**WEST SUSSEX COUNTY COUNCIL
STRATEGIC PLANNING CONSULTATION**

SUBJECT: LU/127/17/DOC- Application for approval of matters reserved by condition imposed under LU/173/16/PL relating to conditions 3-landscape scheme, 4-surface water drainage, 8-road safety audit, 9-Construction Management Plan & 12-Bat Mitigation Measure.

38, East Street, Littlehampton, BN17 6AN

**Fig 1**  
**Site Layout and Access**  
**Routes**

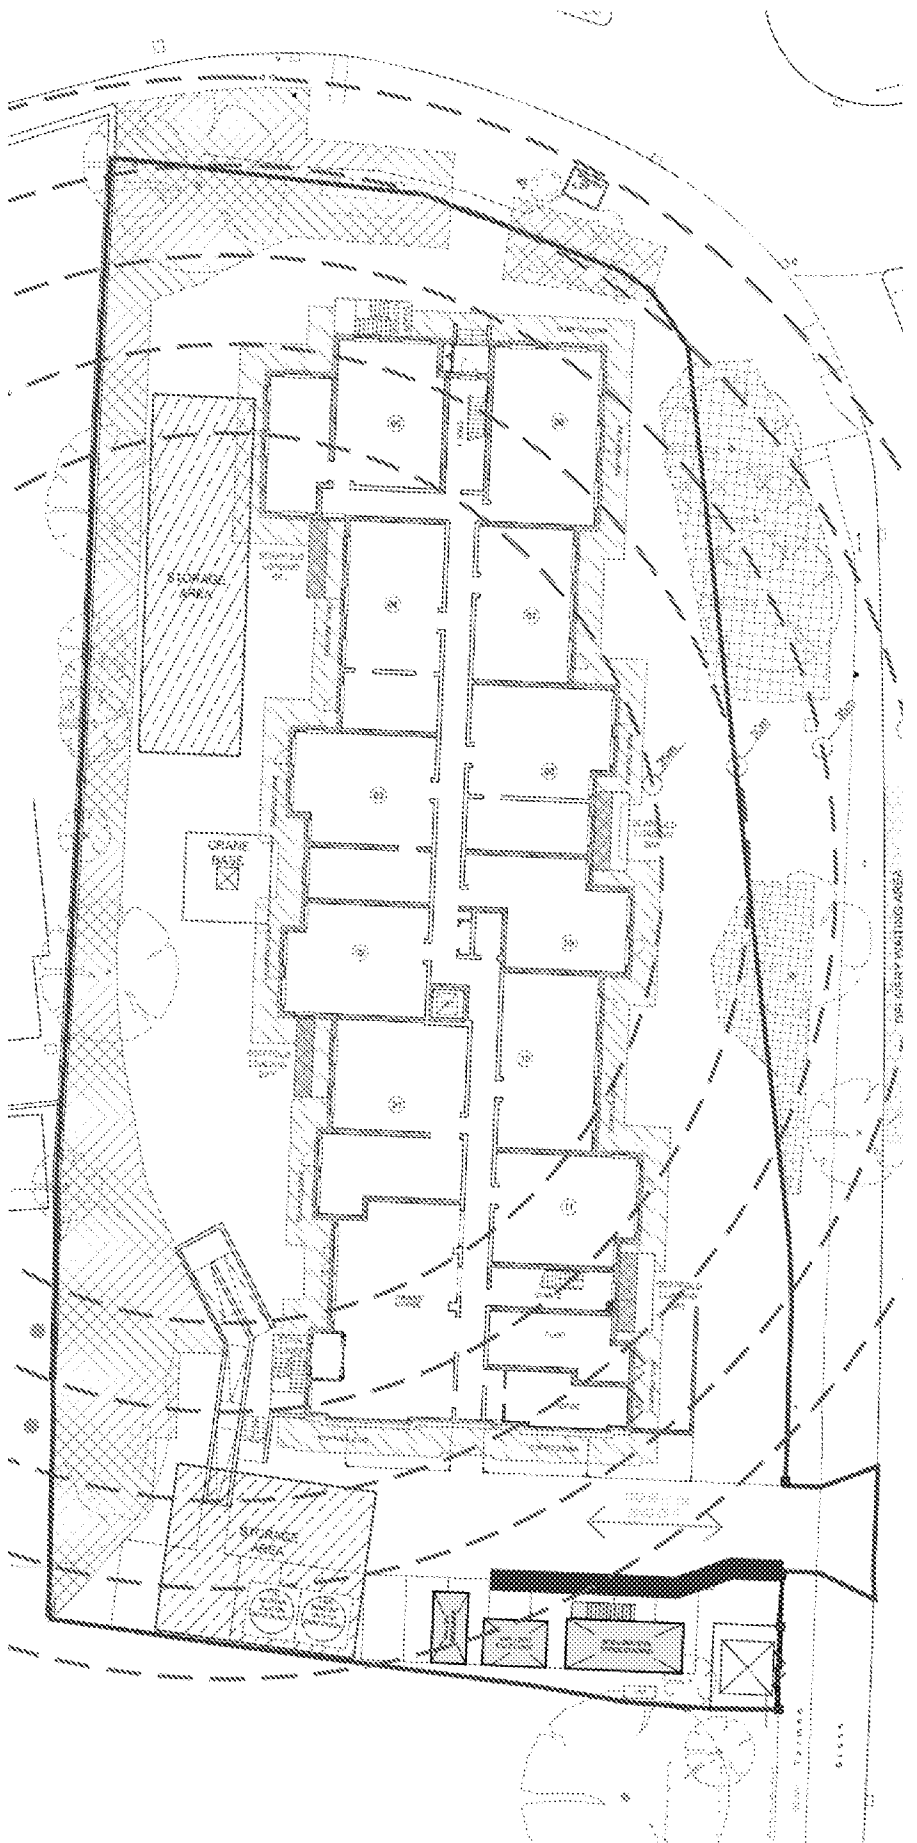
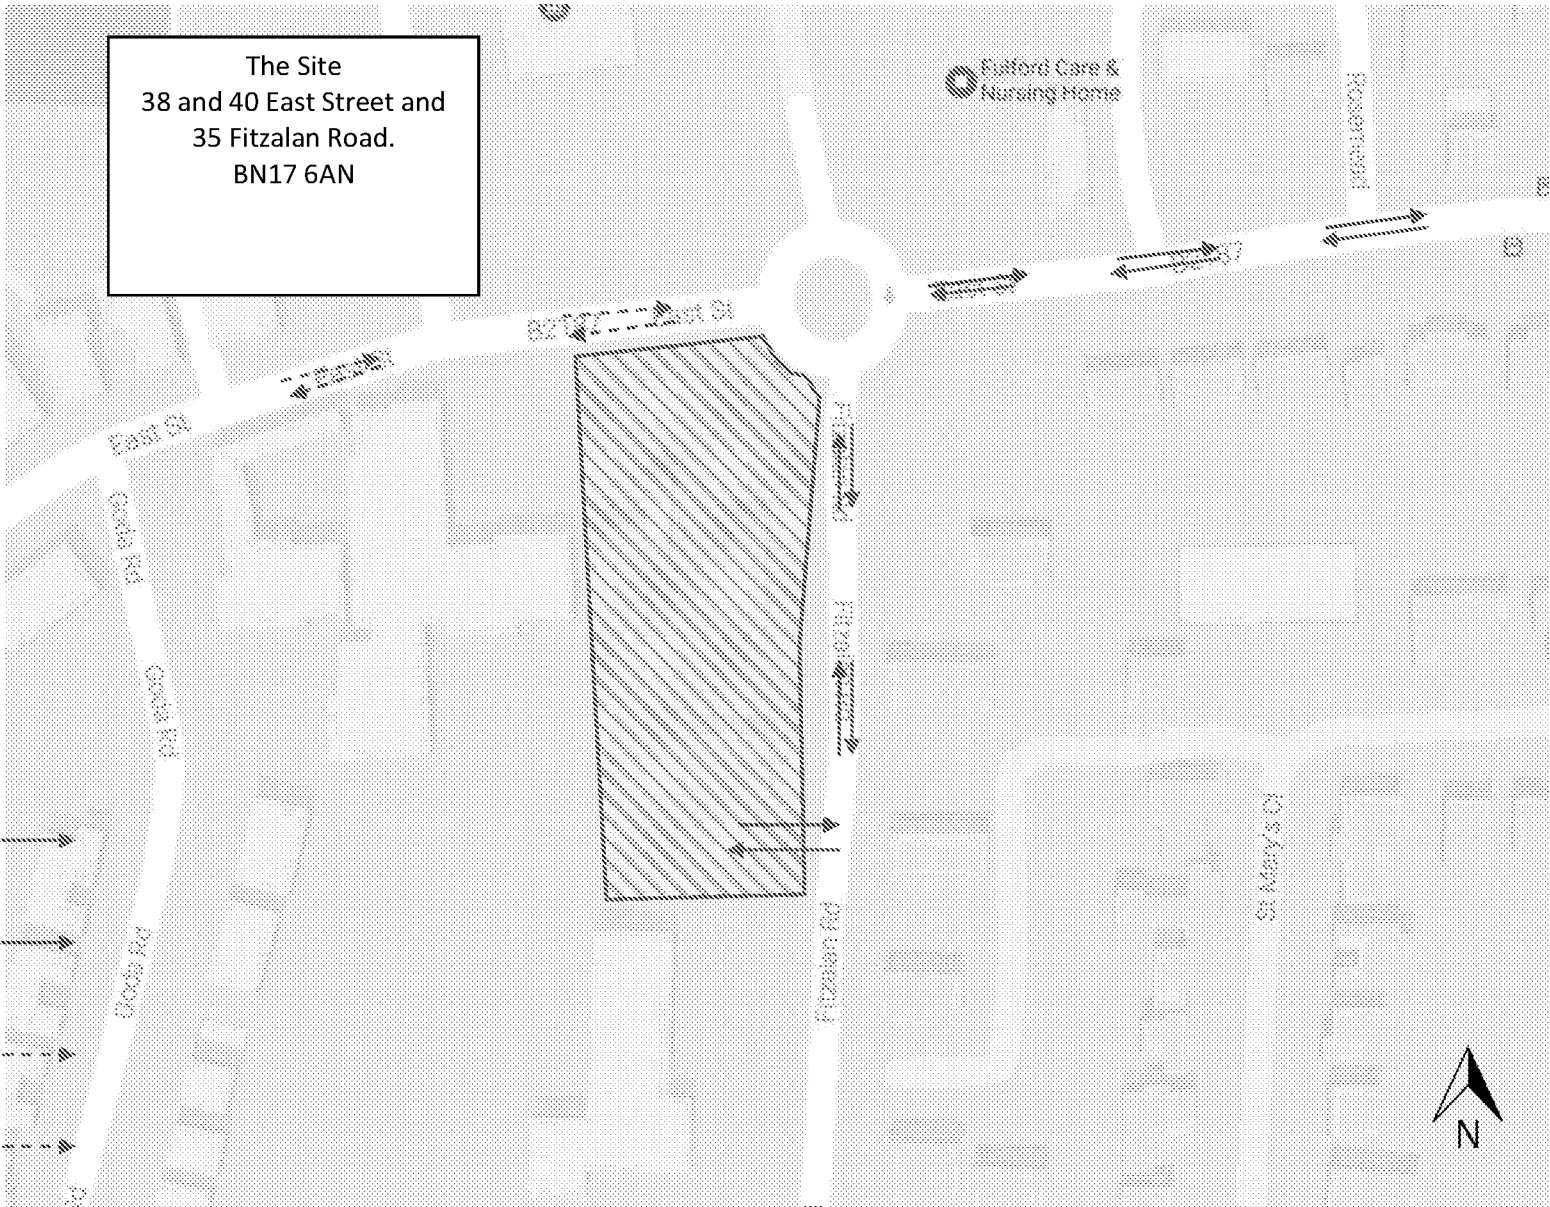
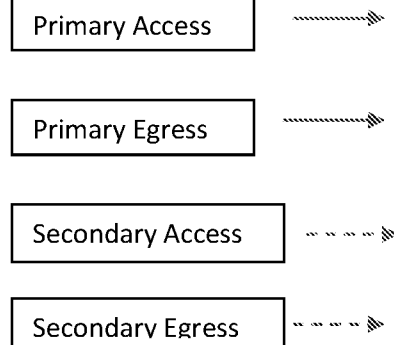
Condition 9 Construction Method Statement (CMS)-The LHA are satisfied with the content of the CMS. We would advise that deliveries endeavour to avoid peak network operating times of 08.00-09.00 and 16.00-17.00. On that basis the LHA are content that this condition can be discharged.
